Recommendation Report for Works to Tree(s) on trees subject to a Tree Preservation Order (TPO)

REF NO: AW/30/21/T

LOCATION: 55 Christchurch Crescent
Aldwick
PO21 5SJ

PROPOSAL: 3 No. Corsican Pine trees - Crown reduction to height approx. 13.5m and spread 10.5m and Crown lift to 3m

Picture No.2

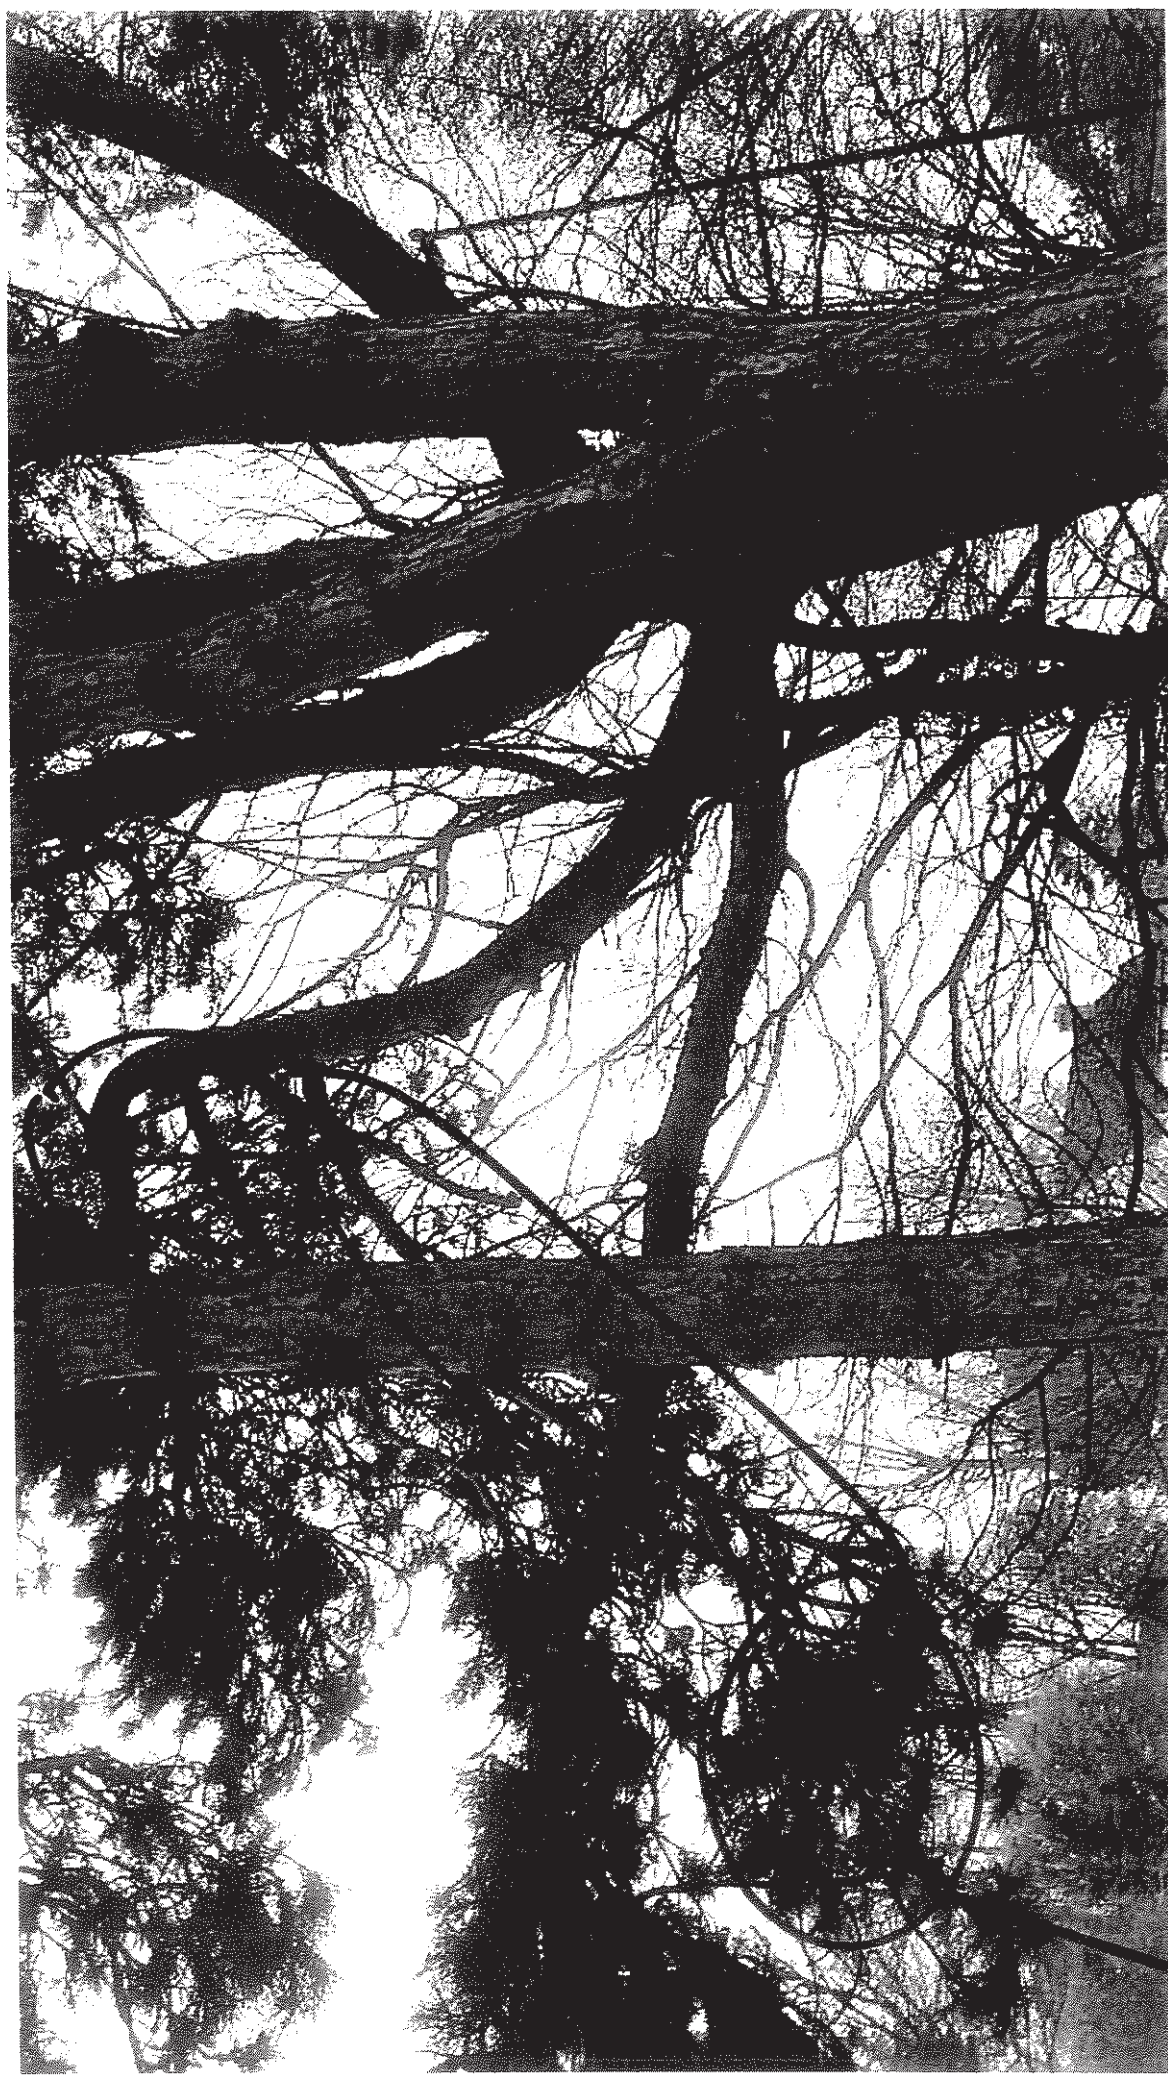
T2 Black pine / *Pinus nigra* subsp. *Maritima* Height: 10-15m Radial spread: 5-10m Age class: Mature

Outwardly and from distance they appear to be in a fair physiological state and assumed to be so in the absence of any evidence to the contrary. Upper crowns are unmodified and display form typical of the species, although T1 and T3 are slightly suppressed by the dominant middle tree (T2). Group crown profile is visually impressive and can be seen from numerous properties and by users of the public highway (footway and carriageway).

Overhead clearance of the property appears adequate and low branches have been reduced (c2016) to improve lateral clearance of dwelling.

Pine have a poor tolerance of hard pruning and any tip reduction is likely to accelerate decline of those limbs and branches. Reduction pruning should therefore only be undertaken on preserved trees where a risk of failure has been evidenced or is foreseeable.

The trees are important constituents of a significant feature in the local landscape and appear to be in adequately sound and healthy condition. The tree surgery proposed in the application would result in excessive reduction of the trees' landscape impact and undue detriment to the visual amenities of the locality.

I recommend REFUSAL for this application.
